1.14 Response to Additional Issues Raised by the Heritage Council of NSW

| No | Extract | Response |
|--------------------------------|---|---|
| Heritage Council of NSW | | |

Figure 3 Location of additional views assessed in Addendum Visual Impact Assessment

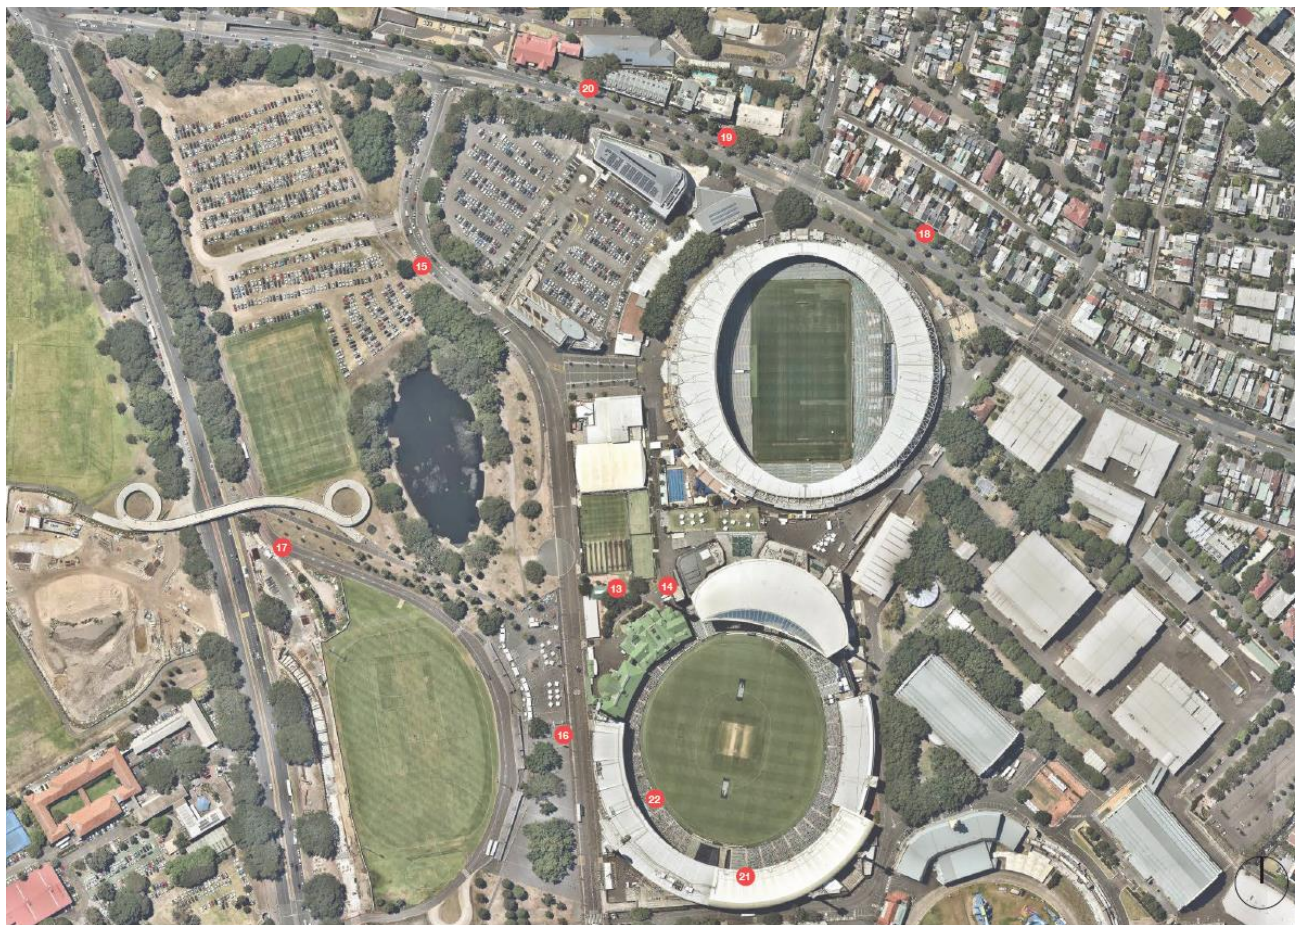
| No | Extract | Response |
|--------------------------------|---|---|
| HC13 | <p>The Heritage Council's previous comments noted that the concept proposal has the potential to adversely impact on significant historic view lines to, from and around local and SHR items and HCAs. An Addendum Visual Impact Assessment (VIA) was provided at Attachment 12 including assessment of additional views from within the SCG. The additional photomontages show that the proposed envelope would visually impact surrounding heritage items and the setting, view lines, and prominence of SHR-listed SCG - Members Stand and Lady Members Stand (particularly in views no. 16, 21 and 22). The VIA provided in the EIS concluded that the proposal does have an impact on close range views obtained from the SCG. The Addendum VIA in the RTS concludes from the additional visual assessment that the proposal will result in medium visual impact from some locations, primarily from within the SCG grandstands and surrounds. The level of visual impact assessed has been elevated from neutral to moderate in relation to the SHR item.</p> <p>It is recommended that the Department consider these impacts in their assessment of the proposed building envelope and require specific measures to be put in place to mitigate and minimise such impacts.</p> | <p>The Applicant notes that the Visual Impact Assessment at Appendix H of the Stage 1 EIS and the Addendum Visual Impact Assessment at Attachment 12 to the Response to Submissions do not determine that there will be any unacceptable visual impacts to SHR items or HCAs as a result of the development. The assessed visual impacts are considered to be adequately addressed by the Final Mitigation Measures at section 5.1 in relation to the concept proposal. The relevant mitigation measures that apply in relation to views from these SHR items and HCAs include:</p> <p>CP:BF1- The Final Urban Design Guidelines prepared by SJB Urban Design (August 2018) are to be adopted for the project and inform the Design Excellence Process and Stage 2 Development Application. This mitigation measure requires the implementation of the Built Form Strategy, Public Domain Strategy and Urban Design Guidelines in relation to built form height and scale, materiality, architectural and public domain design (among other guidelines). It is noted that both the VIA and Addendum VIA include an assessment of both the maximum propose building envelope (the 'loose fit envelope') and the reference scheme for the stadium design, which is substantially smaller in terms of massing. Whilst the assessment of impact in the VIA is based upon the loose fit envelope,</p> |

| No | Extract | Response |
|----|---------|---|
| | | <p>the actual visual impact caused by the final stadium design is expected to be less than the assessed impact.</p> <p><i>CP-BF3- The detailed design of the new stadium should have regard to the recommendations of the Visual Impact Assessment prepared by Ethos Urban (June 2018).</i> This mitigation measure requires the recommendations of the Visual Impact Assessment to be implemented in the final design of the stadium that includes minimisation of visual impact through the use of trees to replace any trees that are removed as part of the project.</p> |
